Submittal Transmittal

Date:	10/1/2014
Project #	14-1123 - Seaport Lofts
Submittal #	02
ATTN:	Matt Provencal
RE:	Retaining Wall, Cofferdam & Monitoring

H.B. FLEMING 89 PLEASANT AVENUE SO. PORTLAND, ME 04106 P: 207-799-8514 F: 207-799-8538 www.hbfleming.com	TITLE: SOE Design
	PROJECT: Seaport Lofts
	LOCATION: Portland, ME
	DATE: 09/23/14
	SCALE: As Noted

SITE PLAN

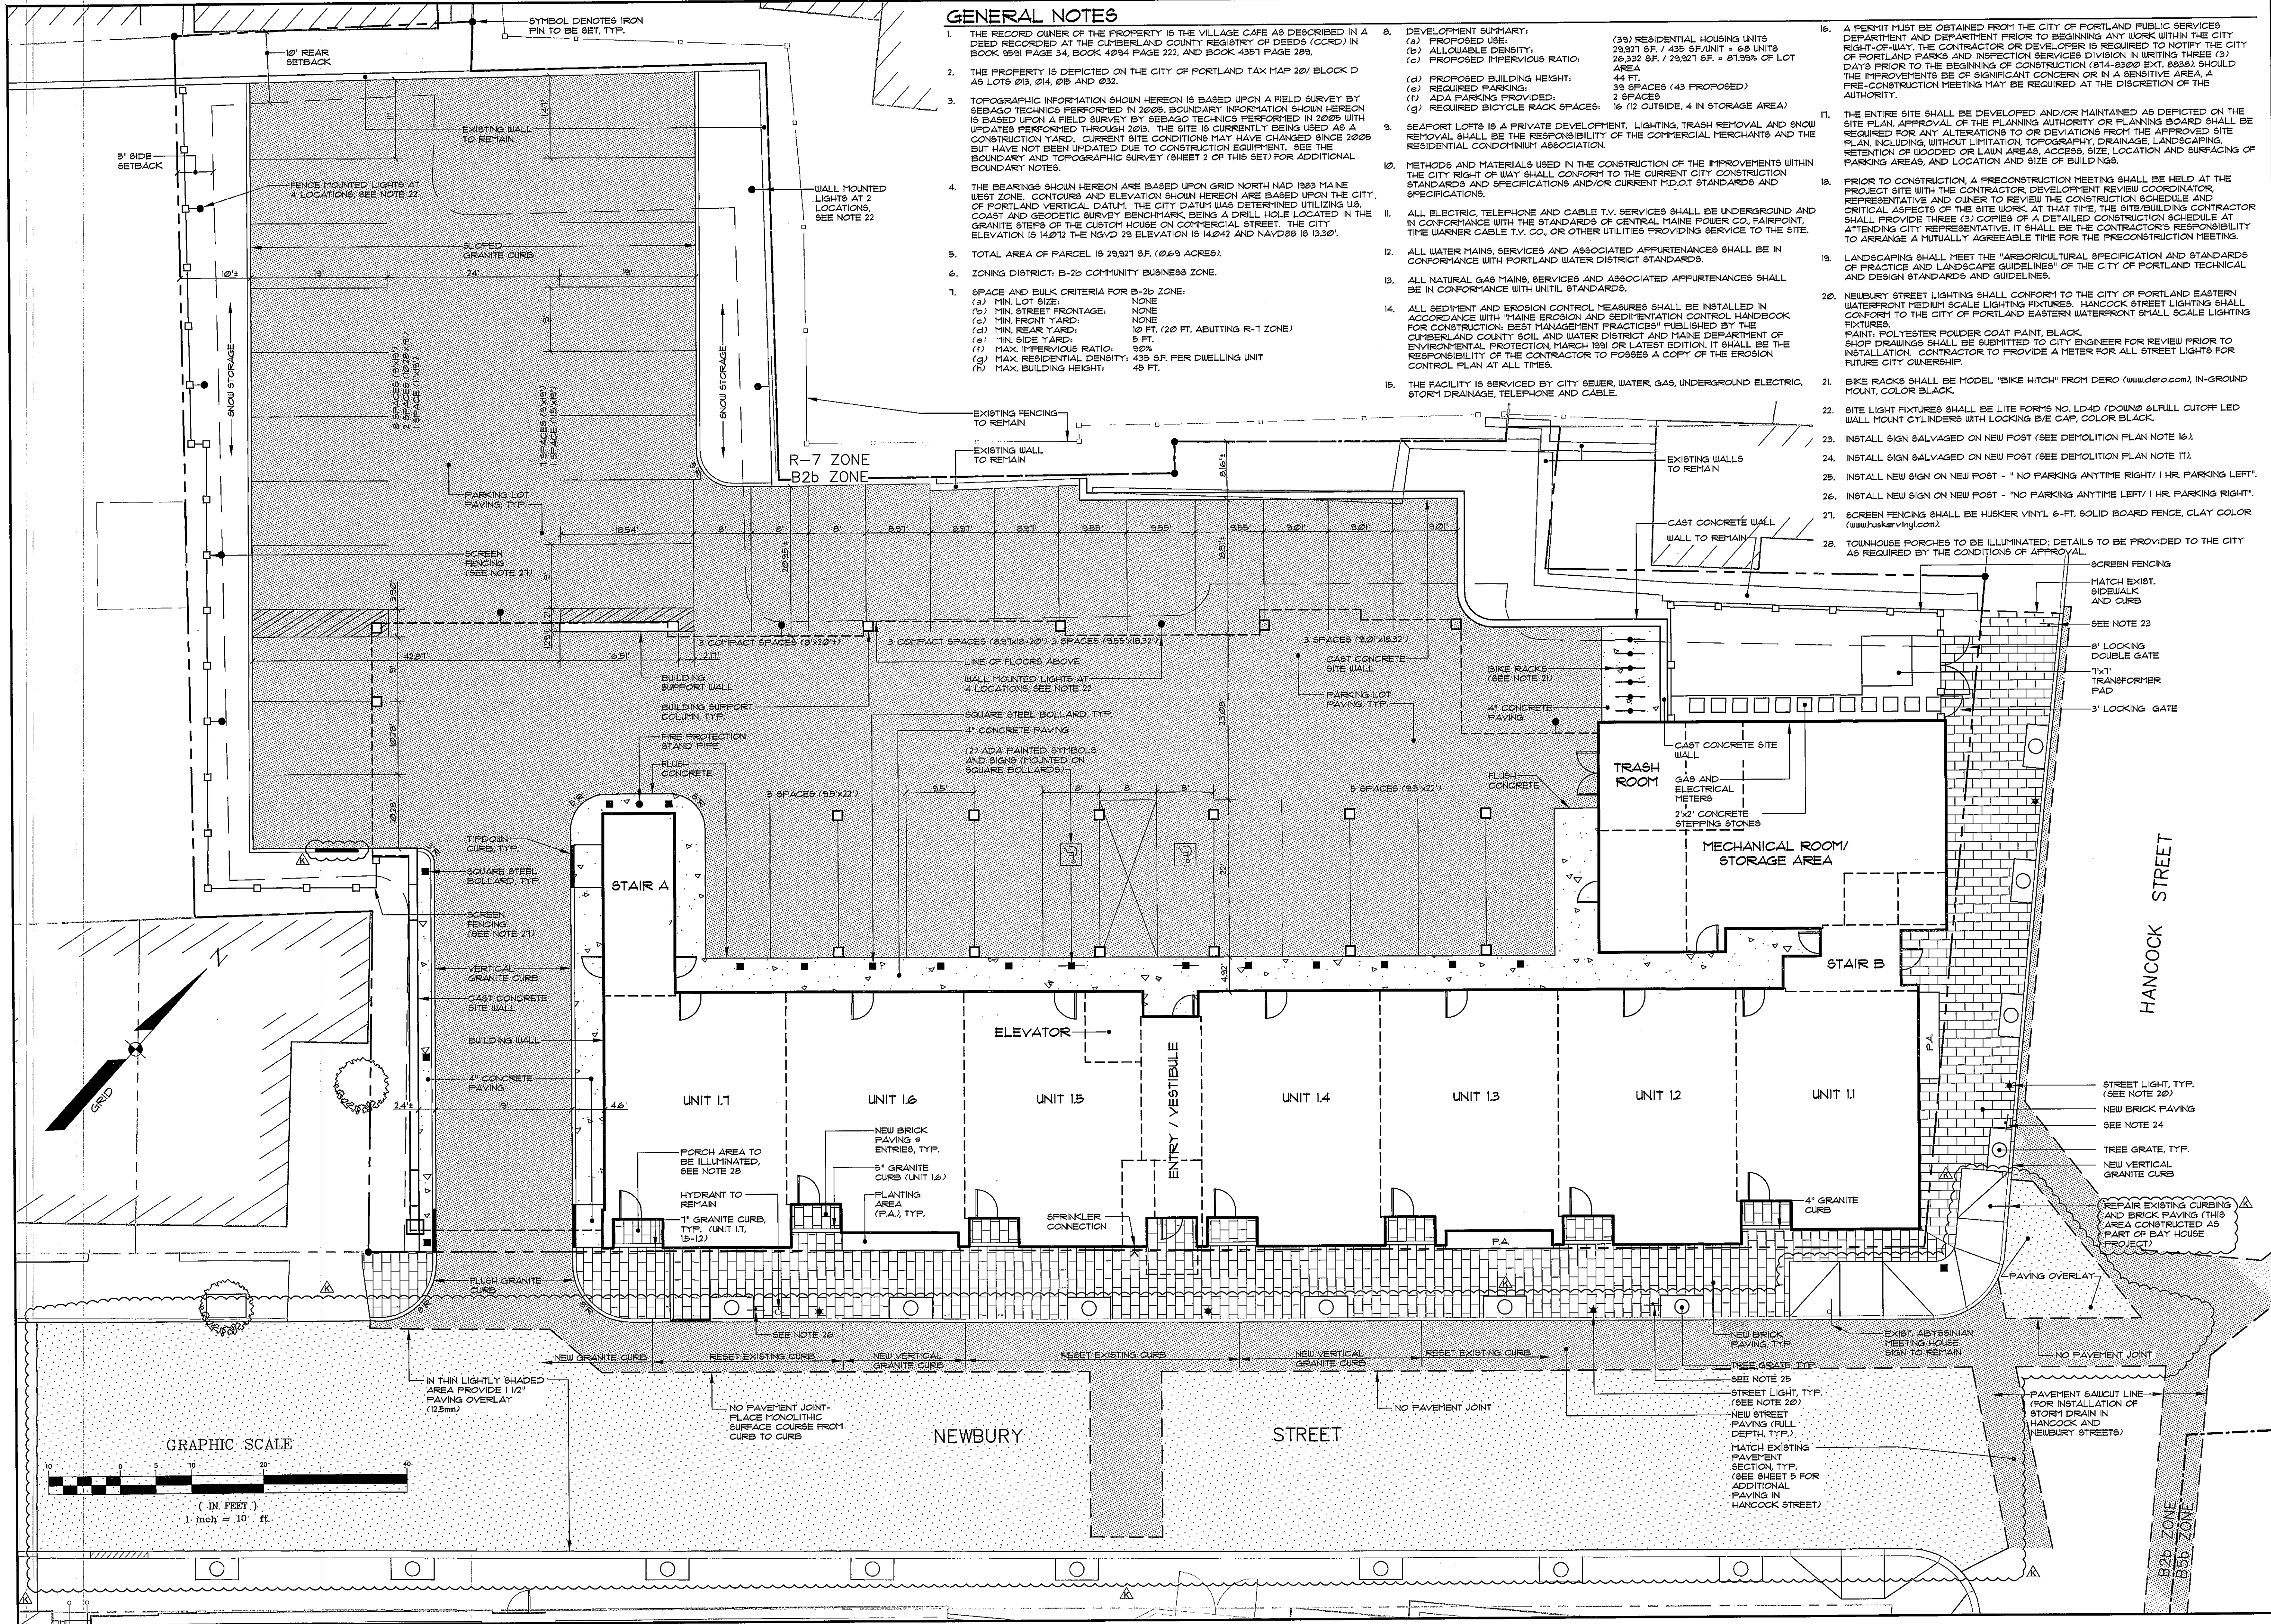
Approx. property line
This area of sheeting on abutting property line. Owner may obtain an easement from abutter, if not, an alternate solution may be necessary.

New retaining wall must be extended and tied into existing retaining wall, as shown on civil drawings

Wall tiebacks may be an option in lieu of proposed wall support if Owner obtains an easement from abutter

Cofferdam design for protection and installation of new retaining wall. Monitoring points to be provided along existing retaining walls

Monitoring point to be provided at this foundation
